4575 Burgess Road Extended Family, AL-17-019

Please accept the following comments from El Paso County Public Health for project referenced above:

SITE PLAN

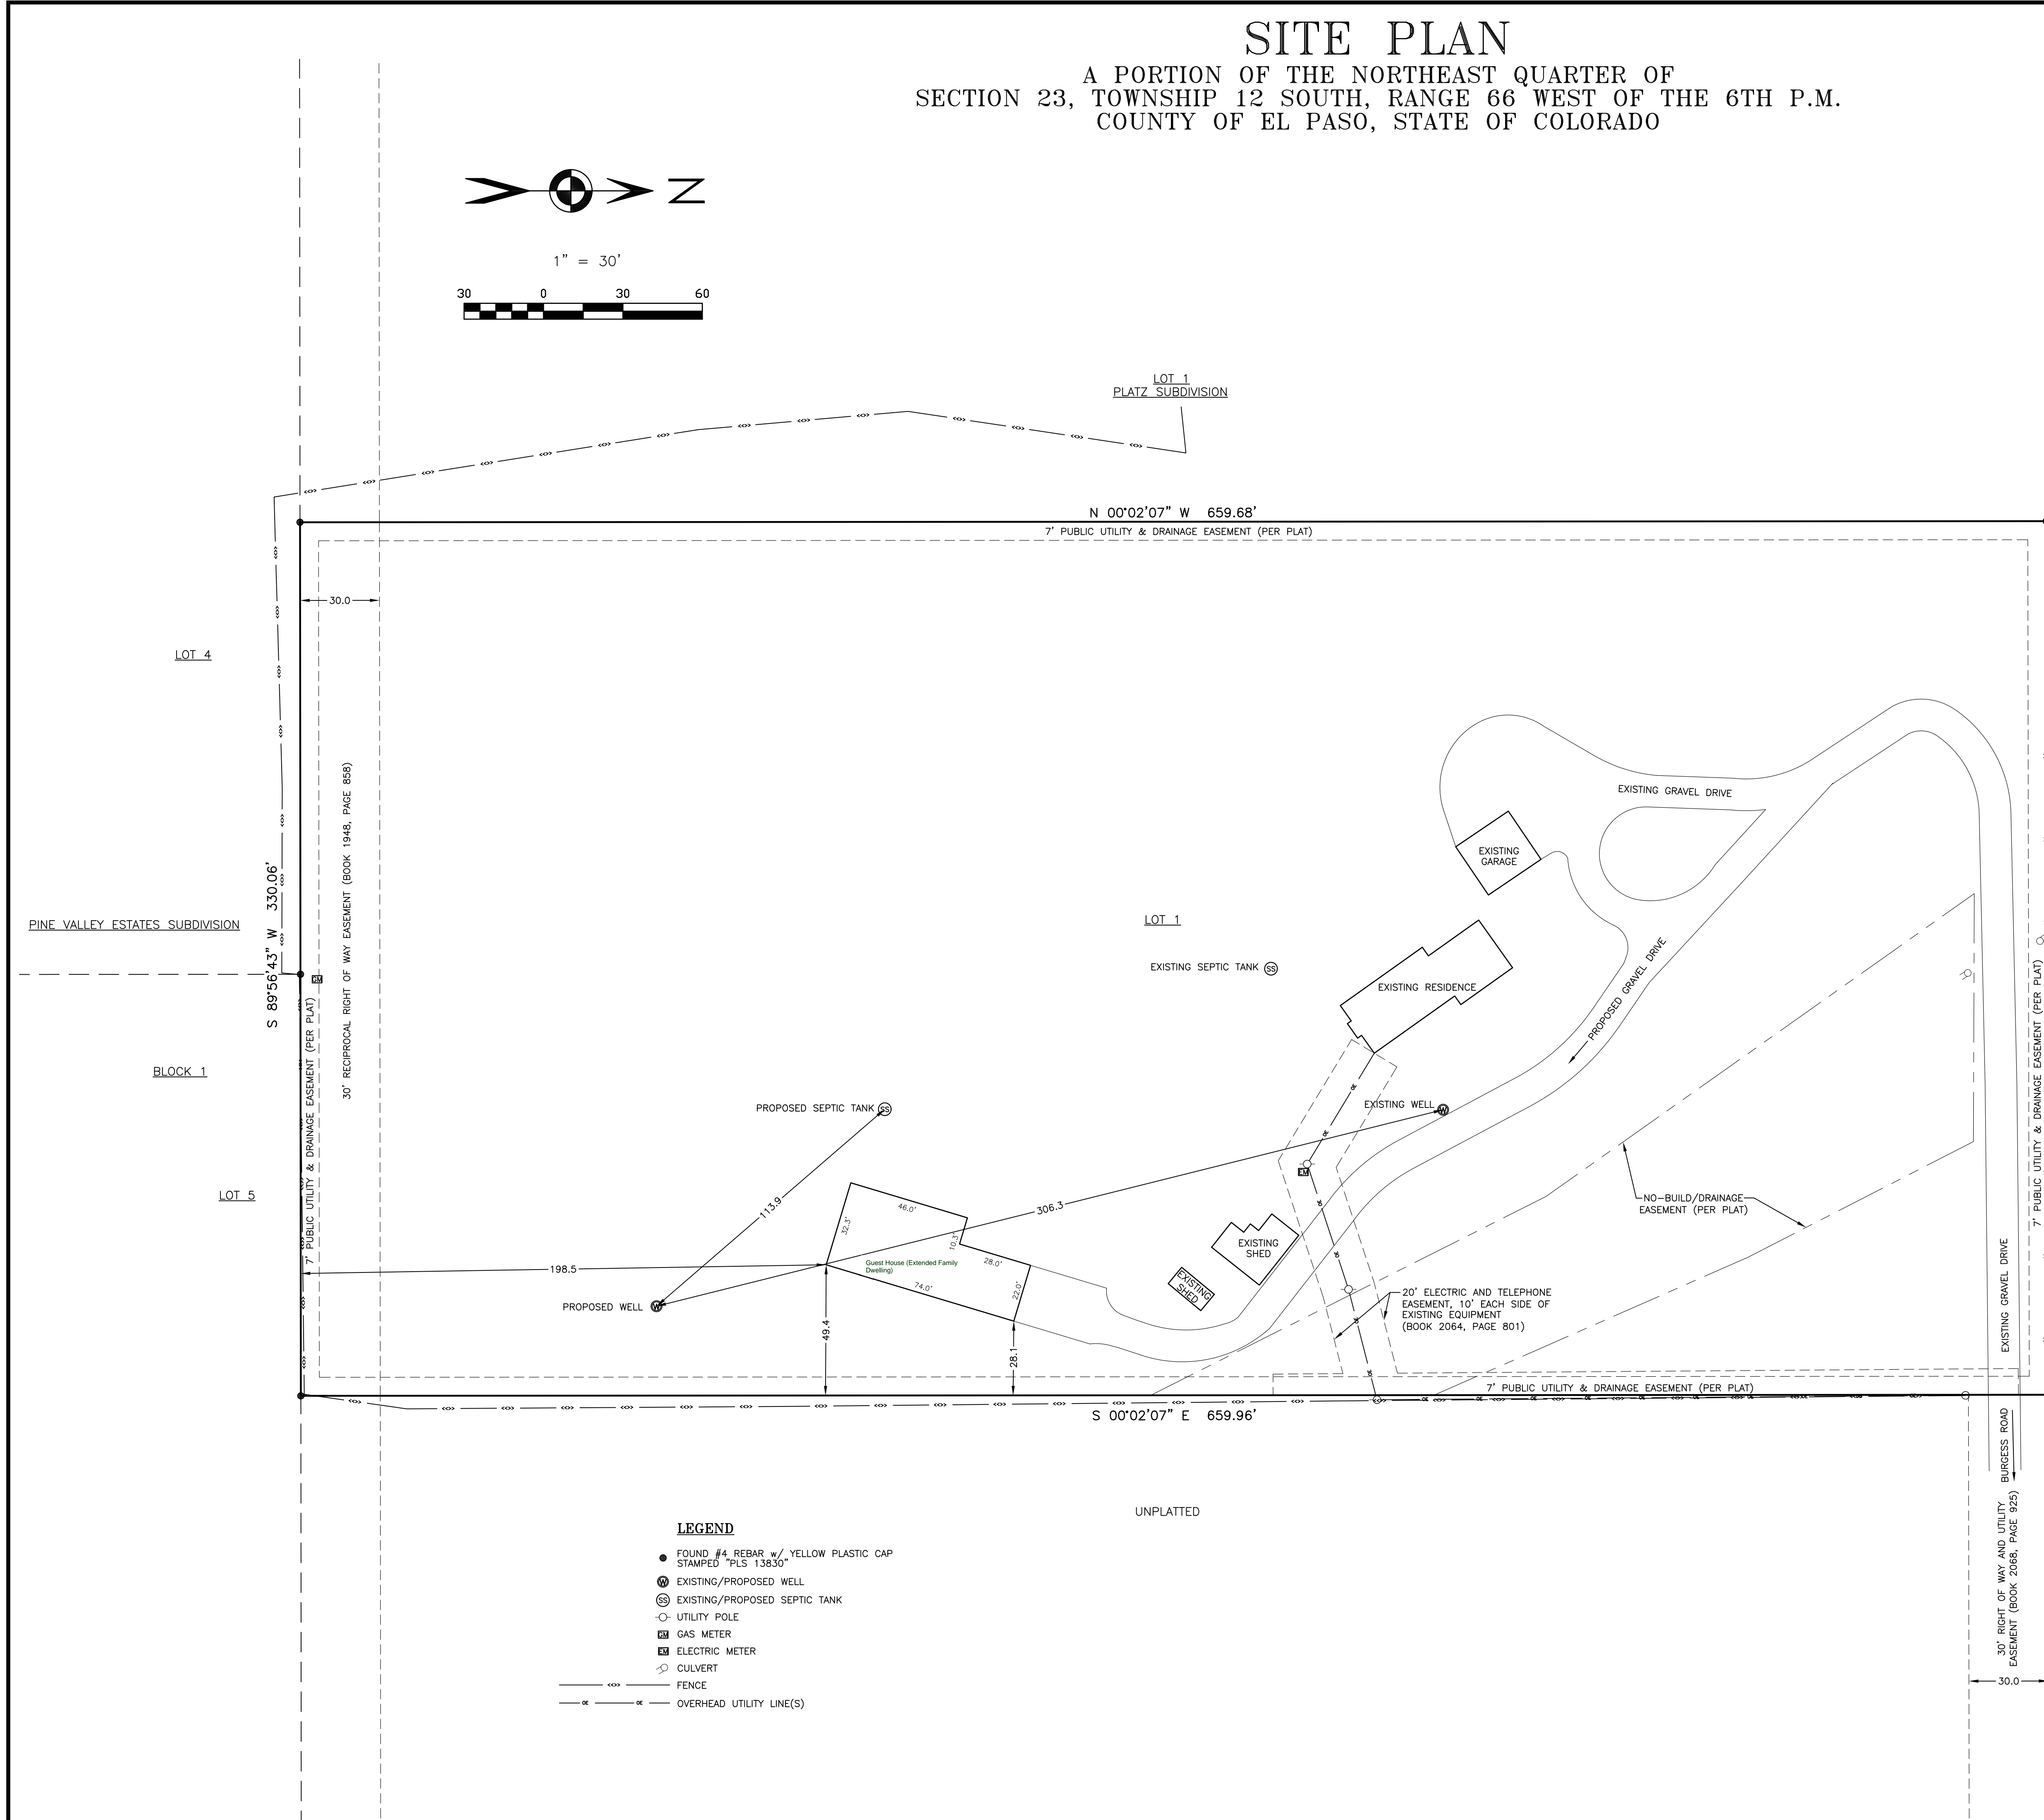
- **The proposed second dwelling will require full compliance with the El Paso County Public Health, Onsite Wastewater Treatment System (OWTS) Regulations. This includes the required setback from all new and existing property lines for both the proposed and existing OWTS.**
